Planning Inspectorate Ref:
EN010112

Conwy County Borough Council Ref:
ENQ/31314

**Application by Awel y Môr Offshore Wind Farm Limited for an Order Granting
Development Consent for the Awel y Môr Offshore Wind Farm project**

Written Representation by Conwy County Borough Council

Wireline drawing

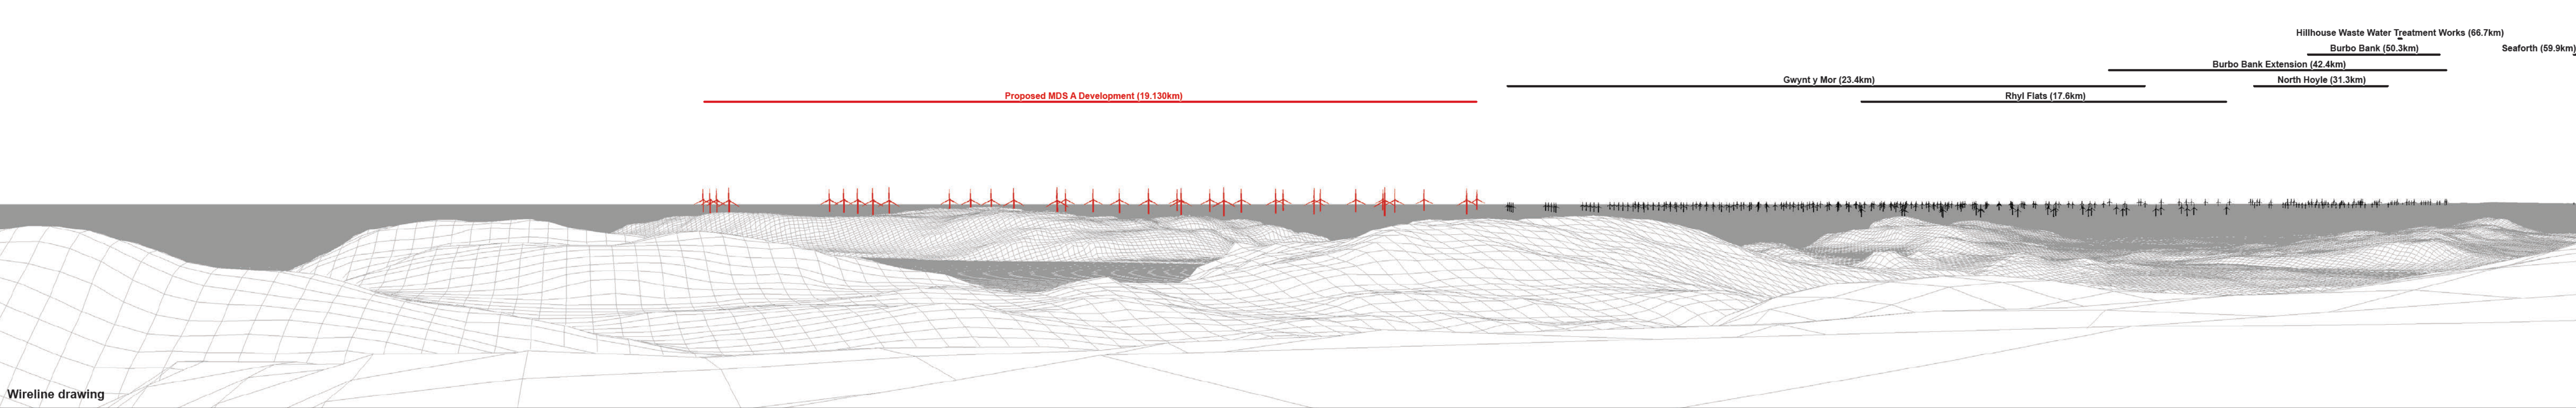
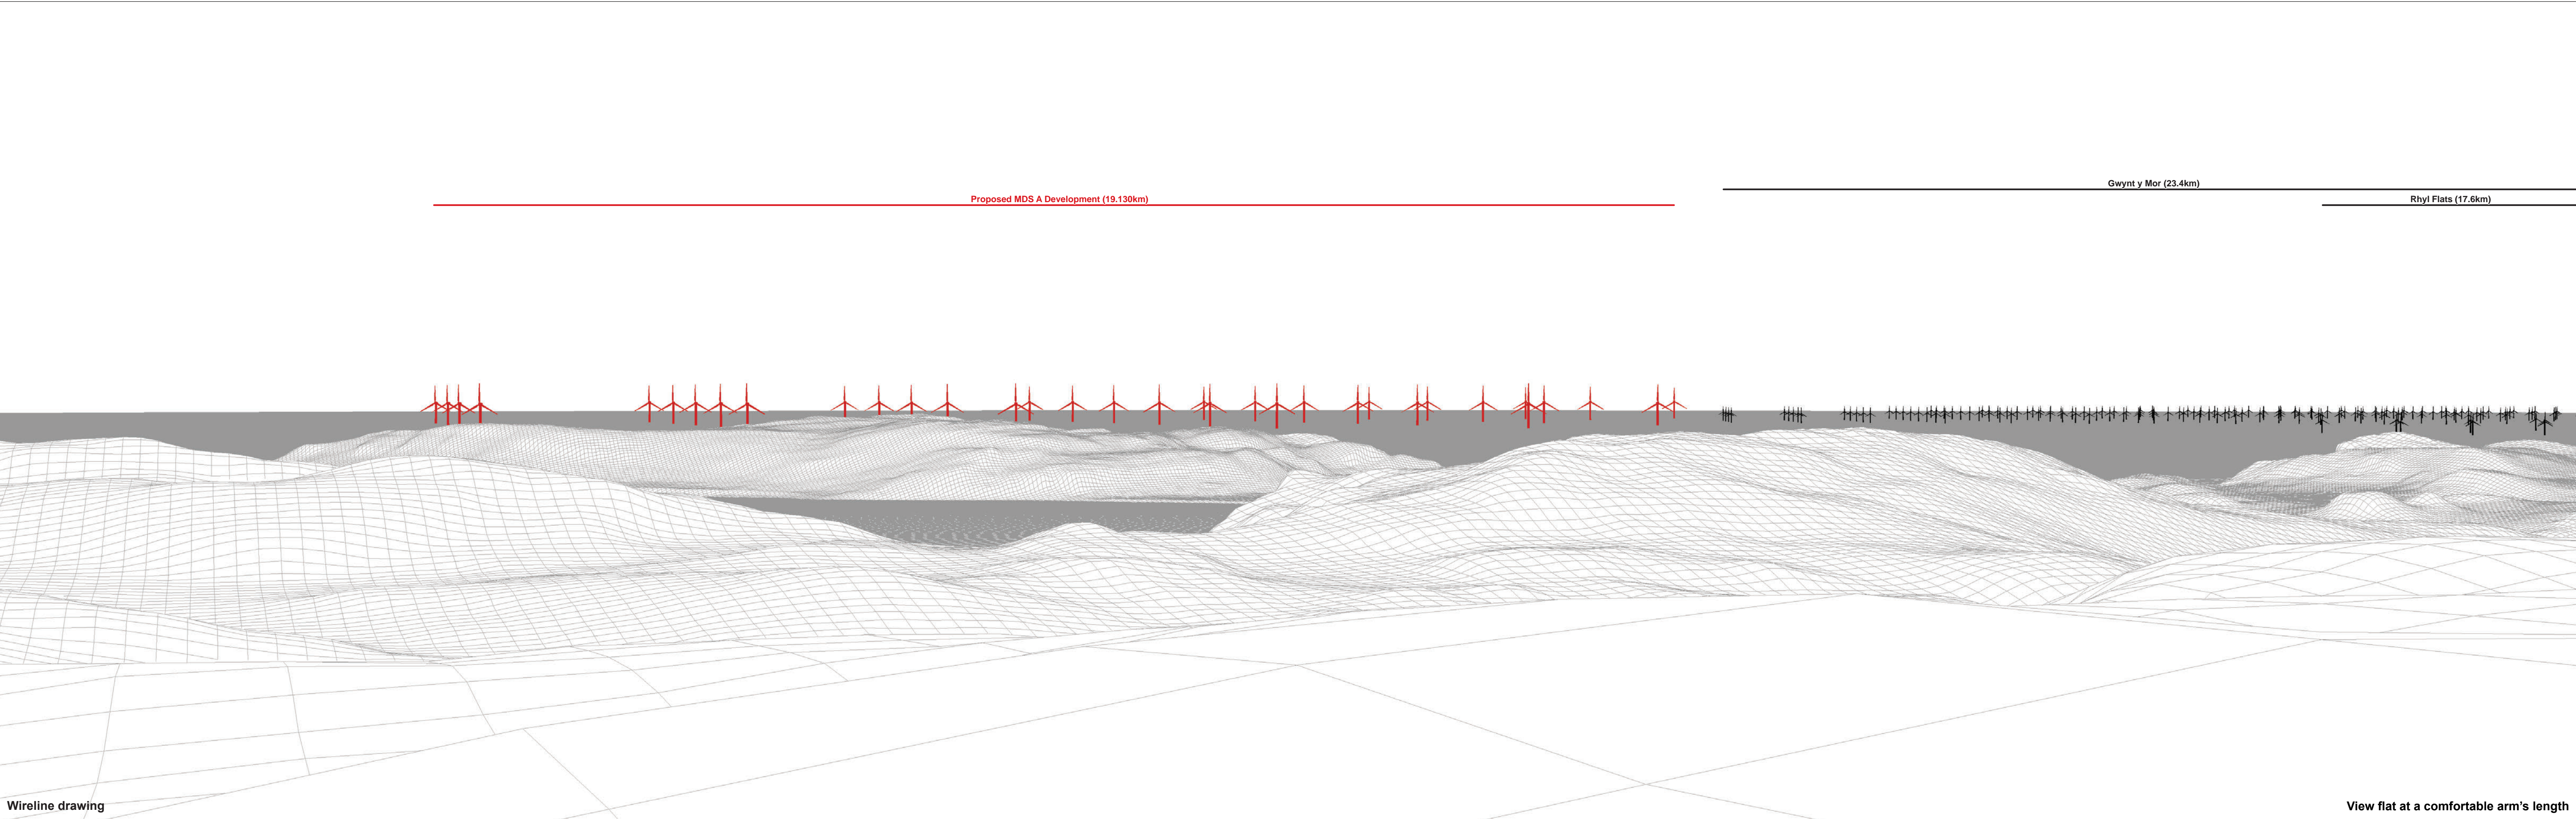
Figure 67c: Above Capelulo (19.13km)

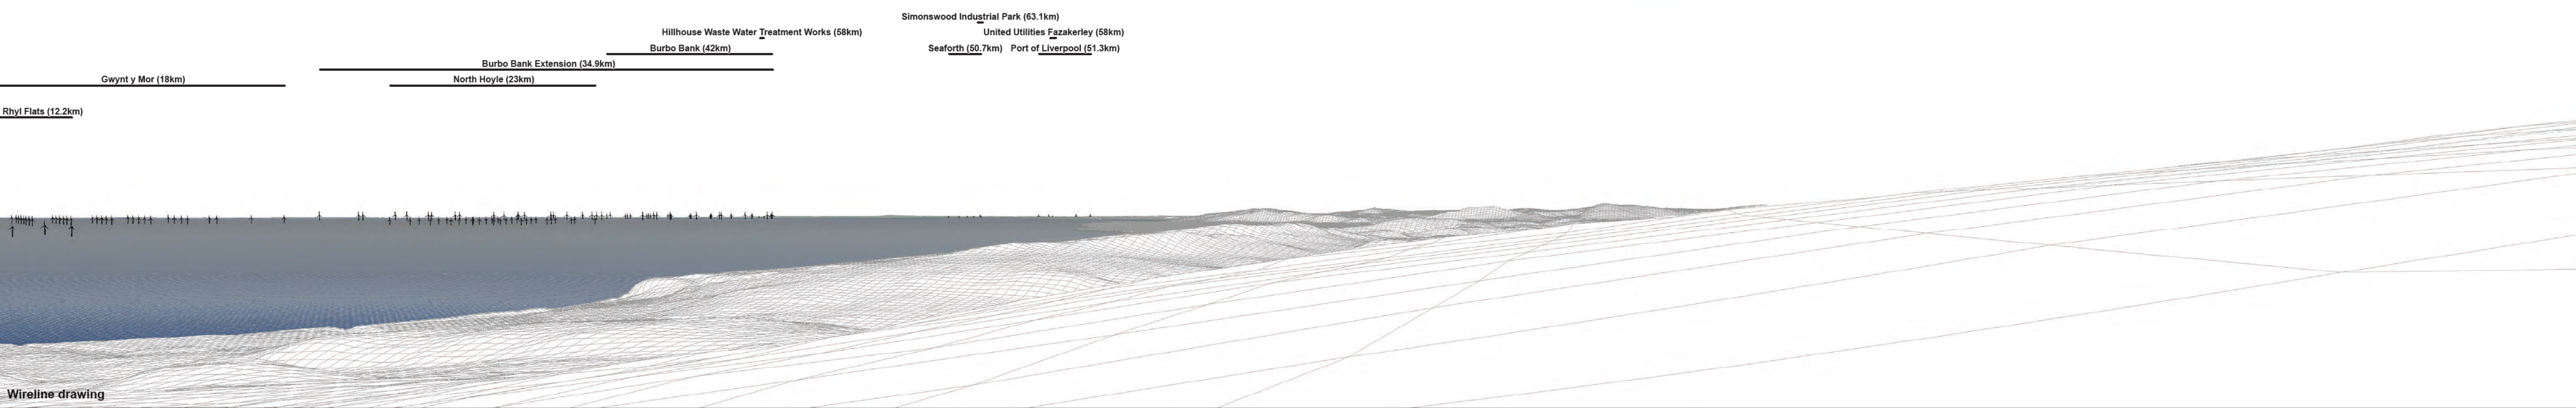
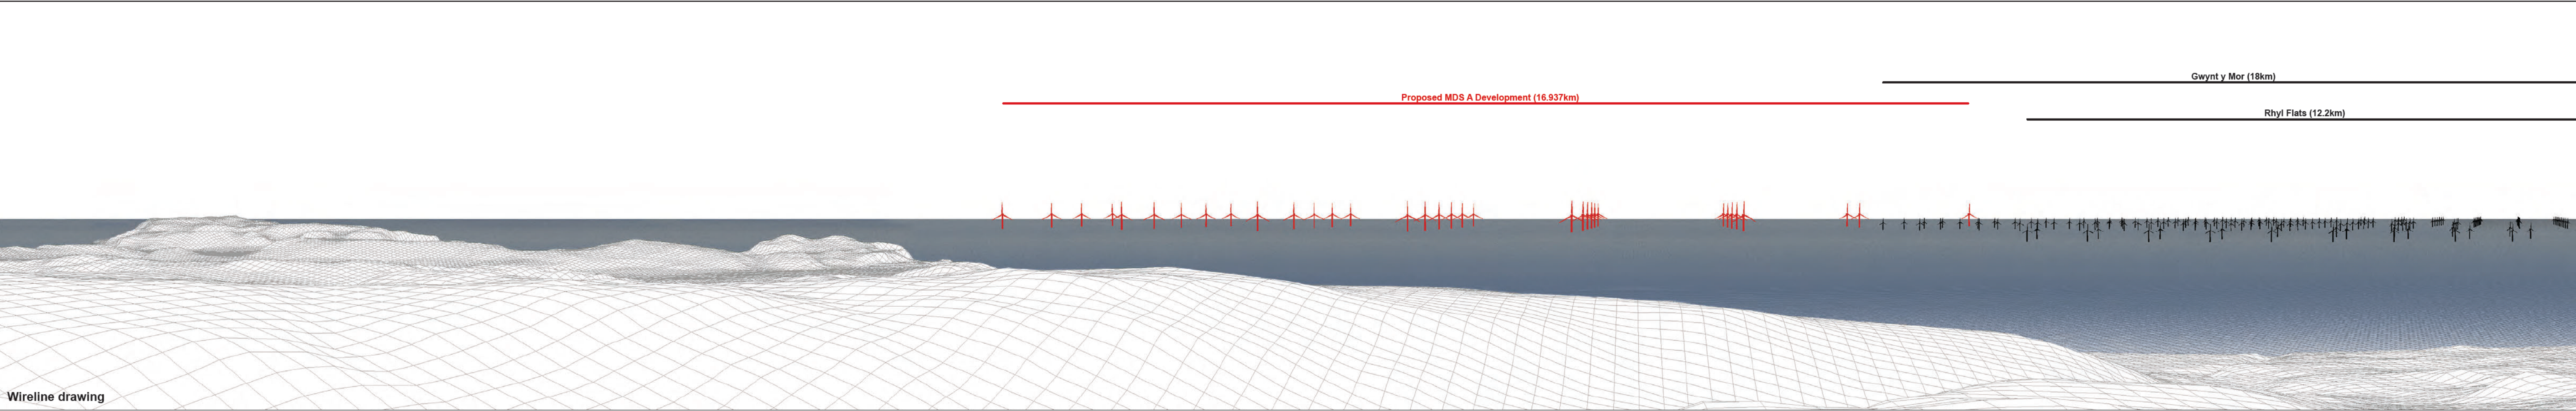
Figure 78b: Footpath above Cilgwyn Mawr (16.936km)
